DRB Application No.: 05DRB-01133 (P&F) Project # 1004281  
Project Name: RIVERVIEW SUBDIVISION  
Agent: Mark Goodwin & Associates Phone No.: 828-2200

Project Name: RIVERVIEW SUBDIVISION

**CITY OF ALBUQUERQUE  
PLANNING DEPARTMENT  
July 20, 2005  
DRB Comments**

SCHLEGEL LEWIS ARCHITECTS agent(s) for VENTURA PACIFIC CAPITAL COMPANY request(s) the above action(s) for all or a portion of Tract(s) H-6A7A1, **RIVERVIEW SUBDIVISION**, zoned SU-1 IP, located on GOLF COURSE RD NW, between PASEO DEL NORTE NW and SHELLY ROSE RD NW containing approximately 1 acre(s). [REF: DRB-97-245] (C-12)

**Elevations**

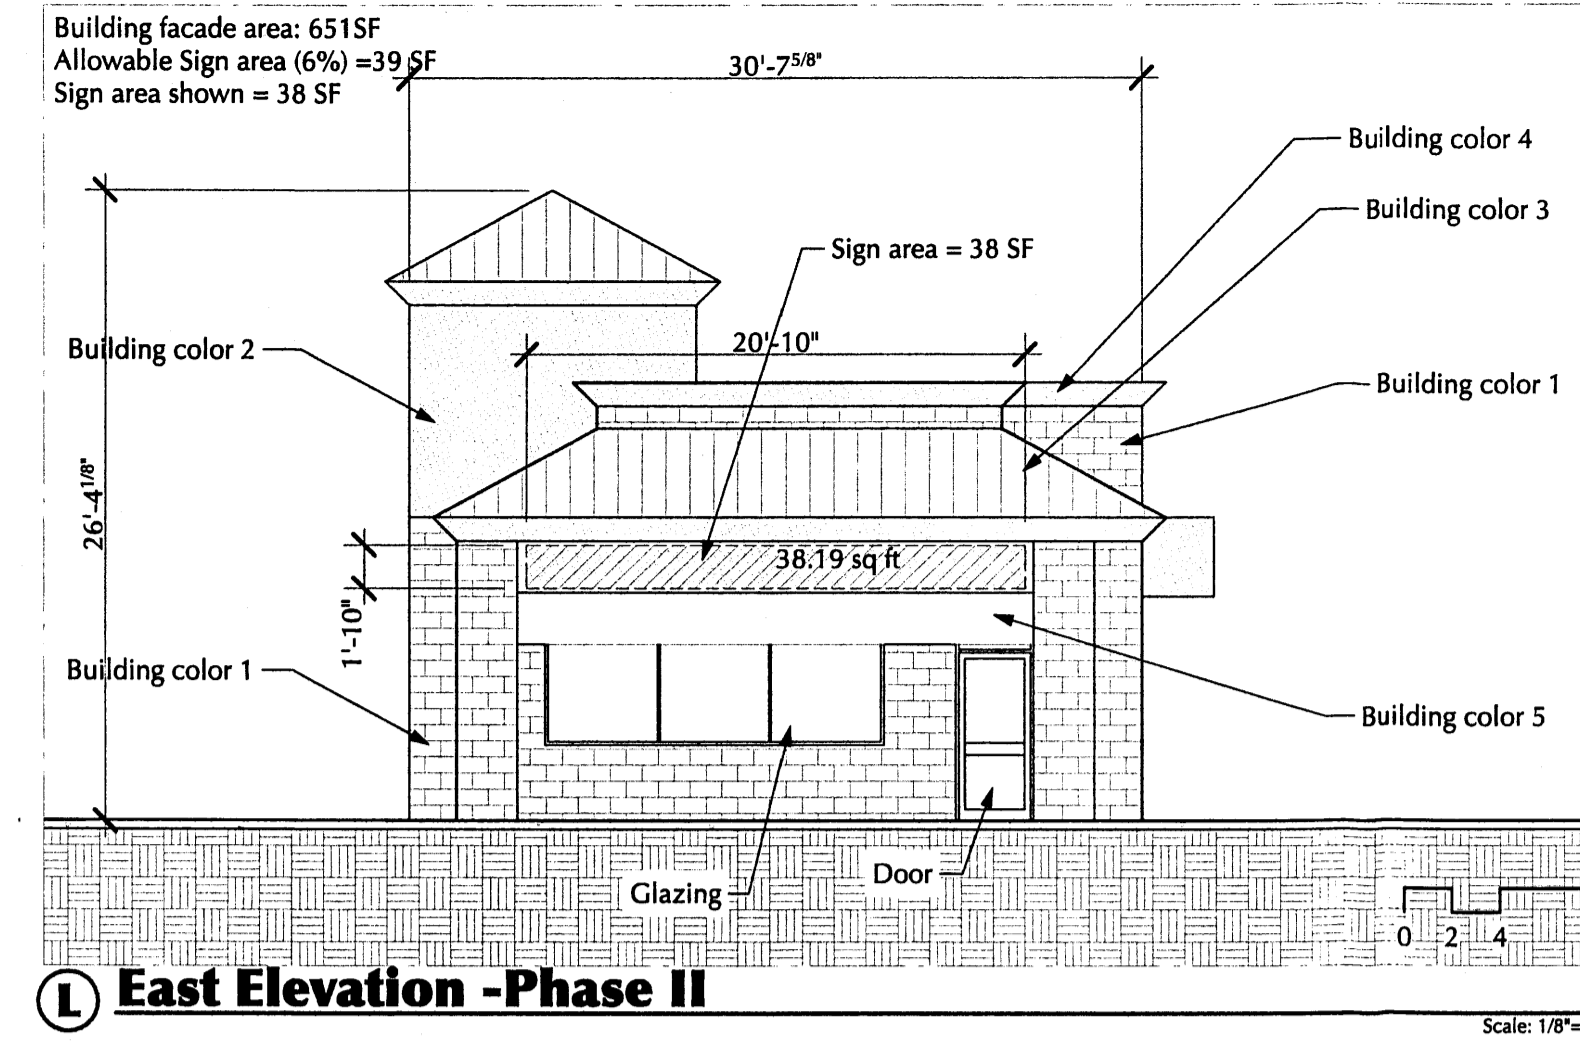
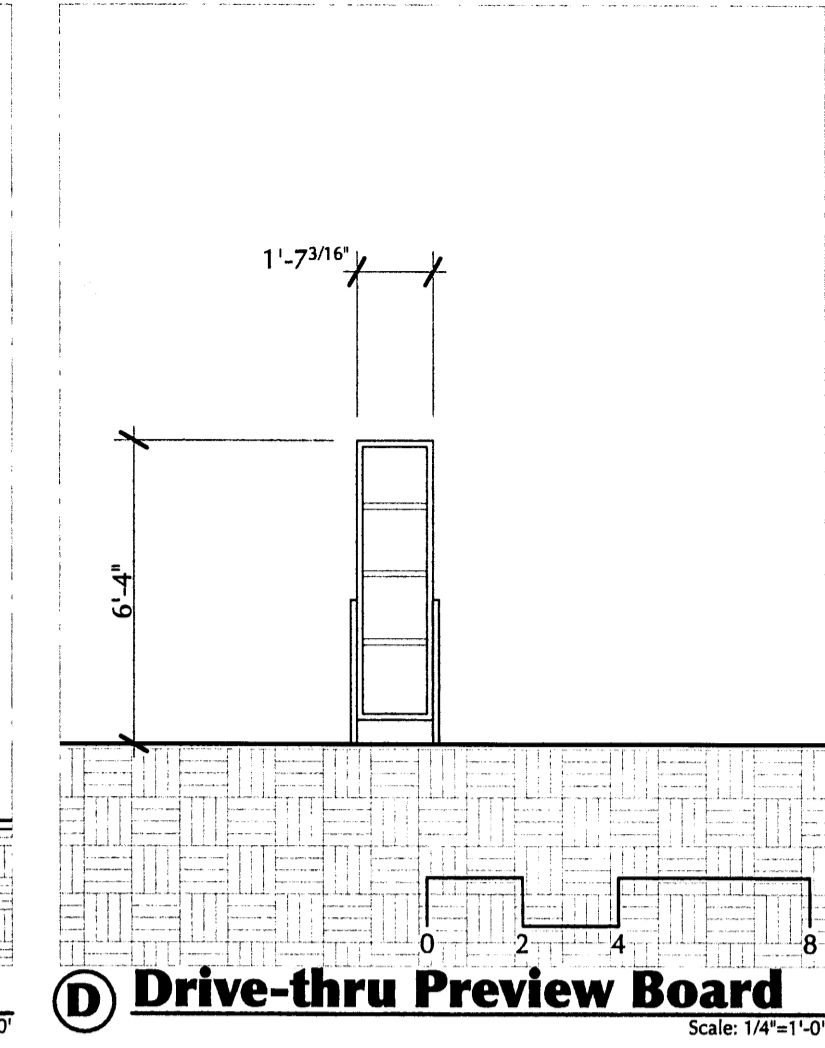
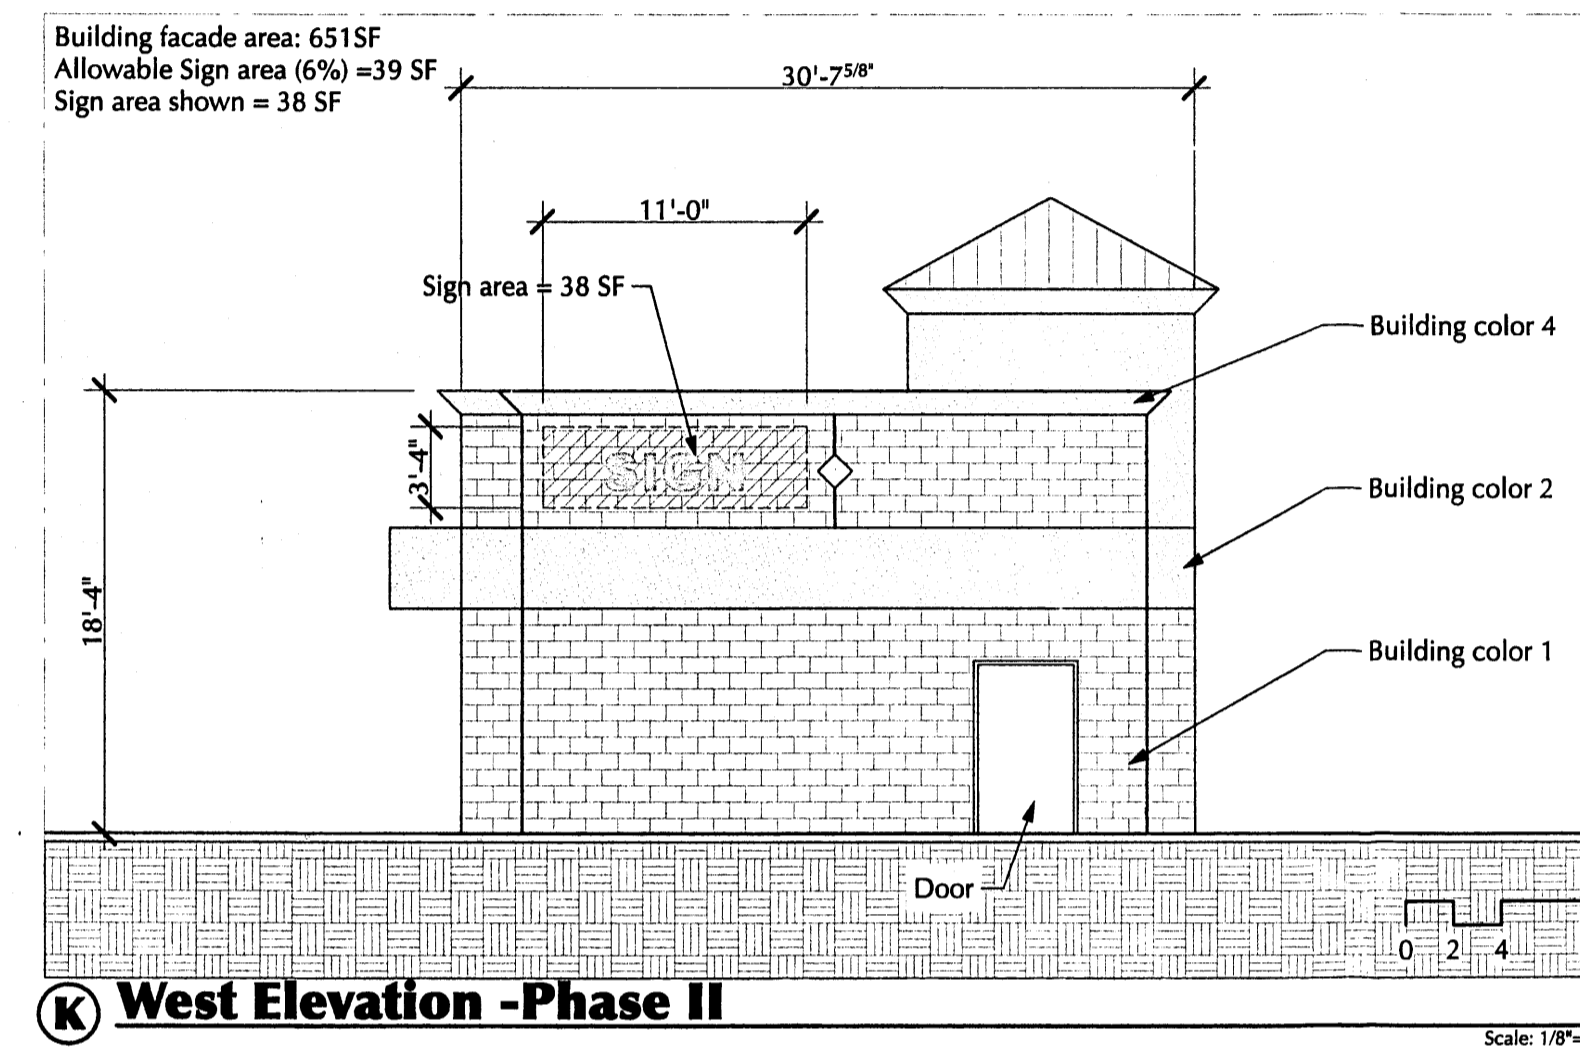
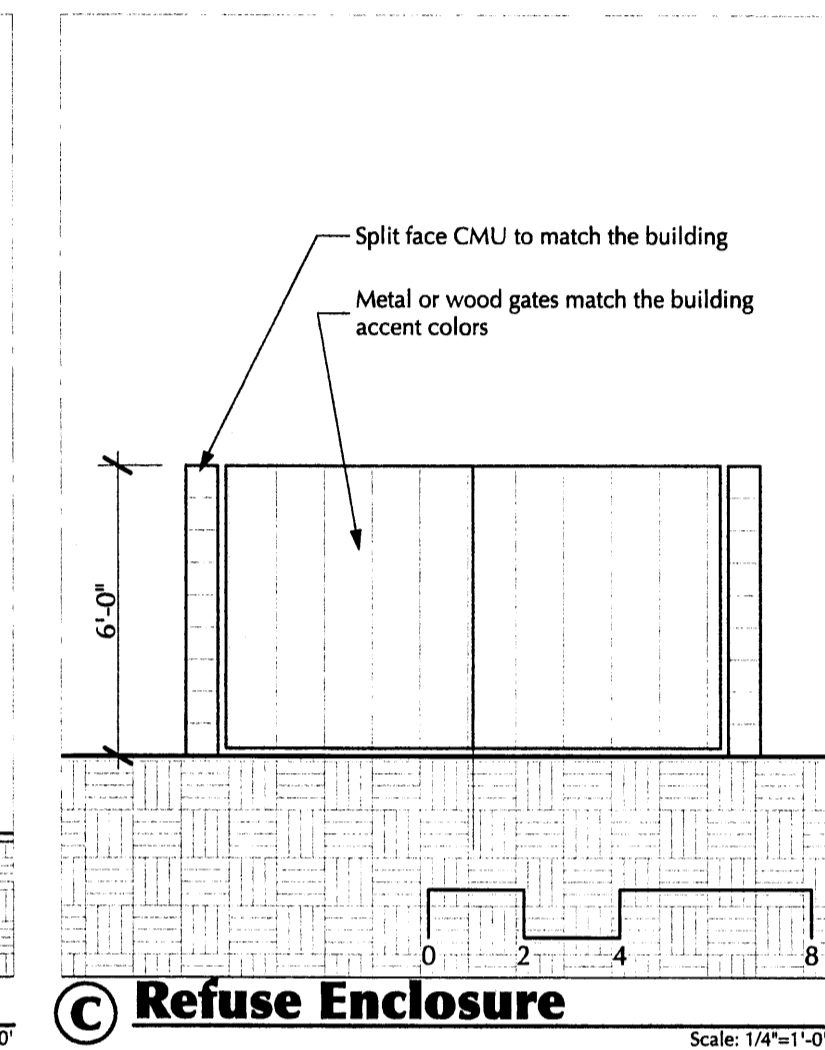
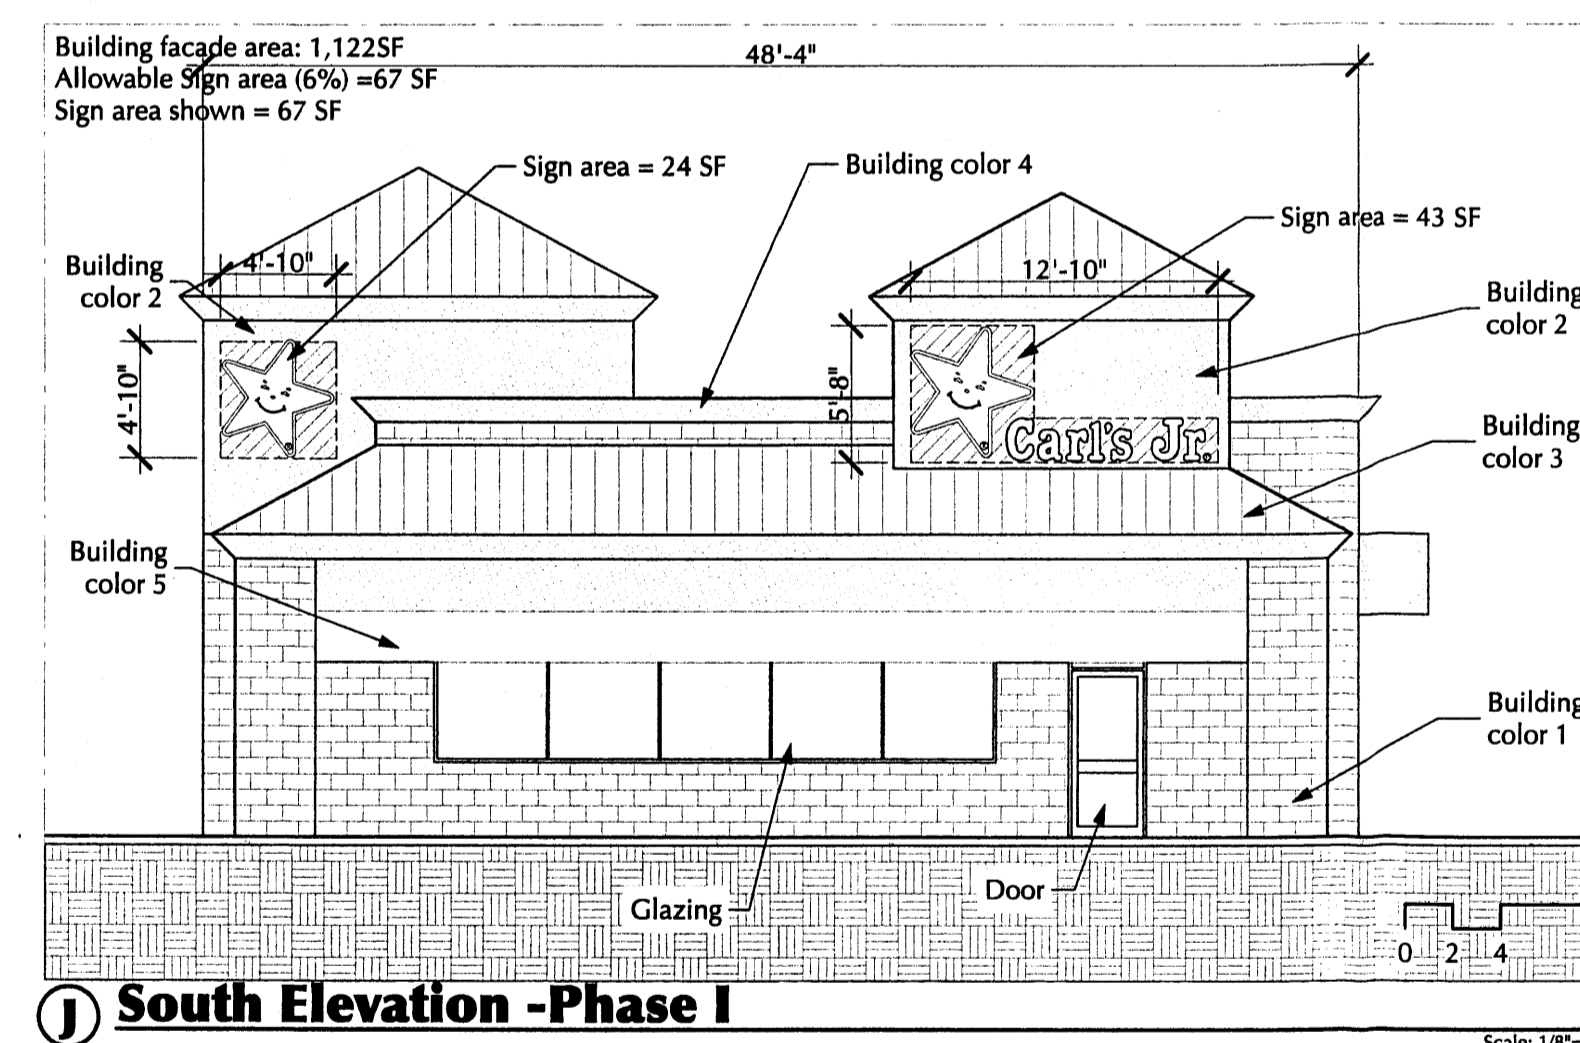
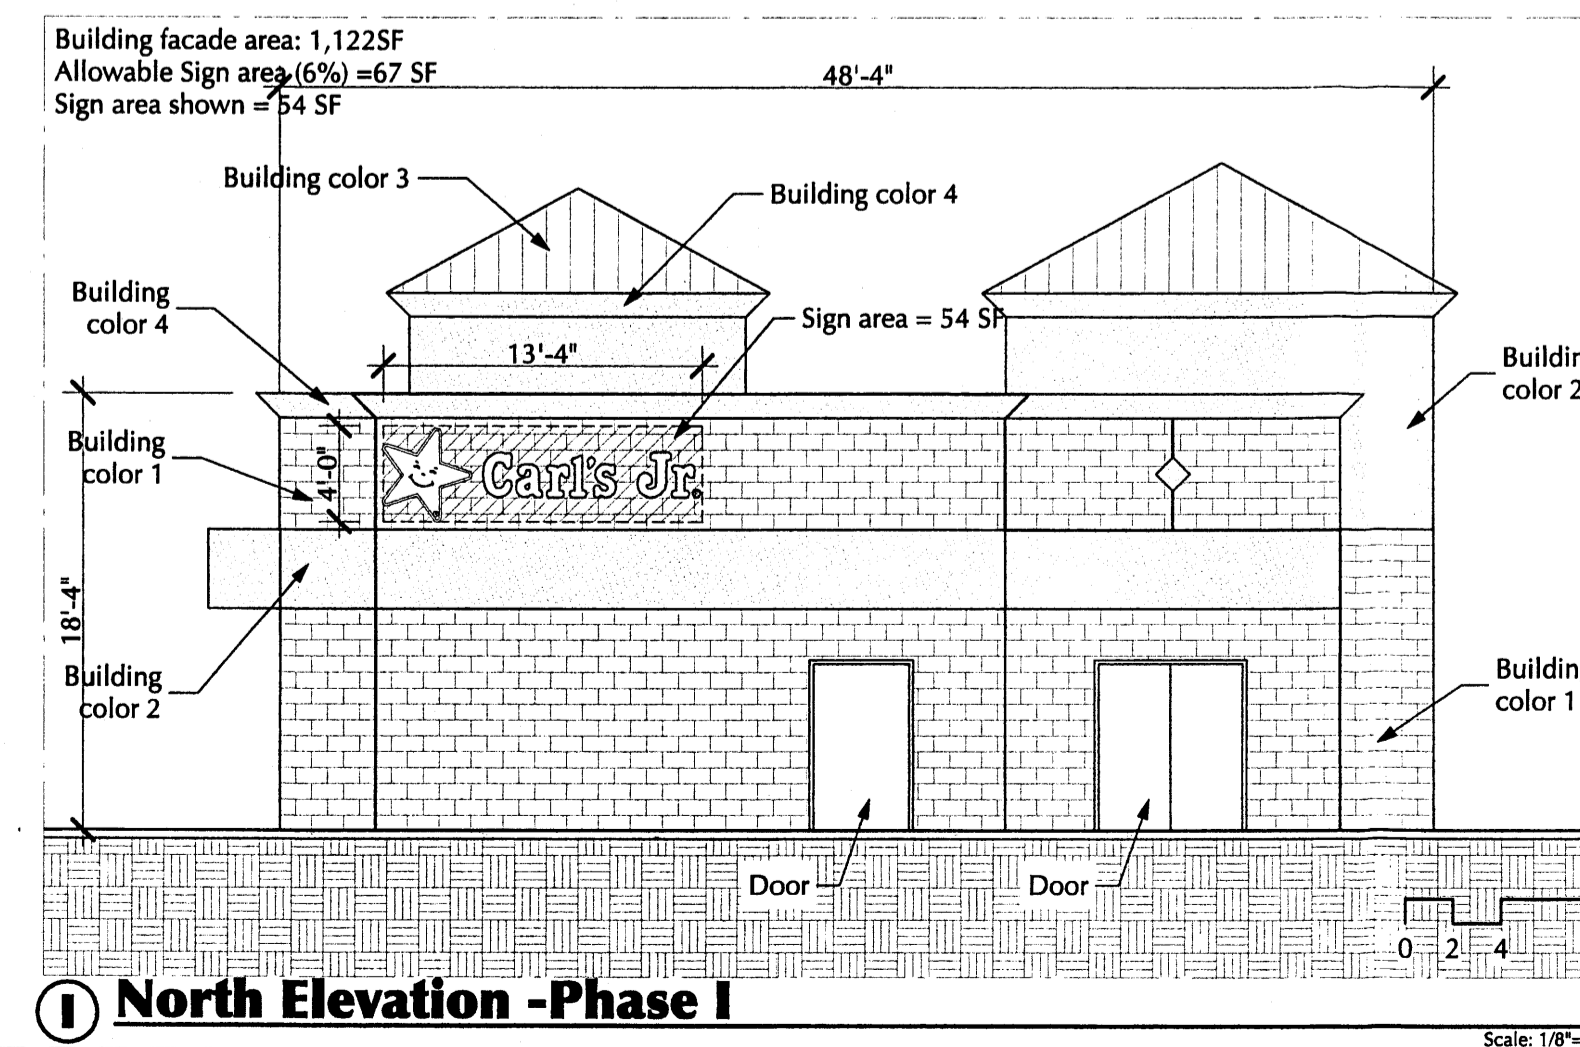
There are 2 West Elevations of Carl's Jr, no East Elevation.
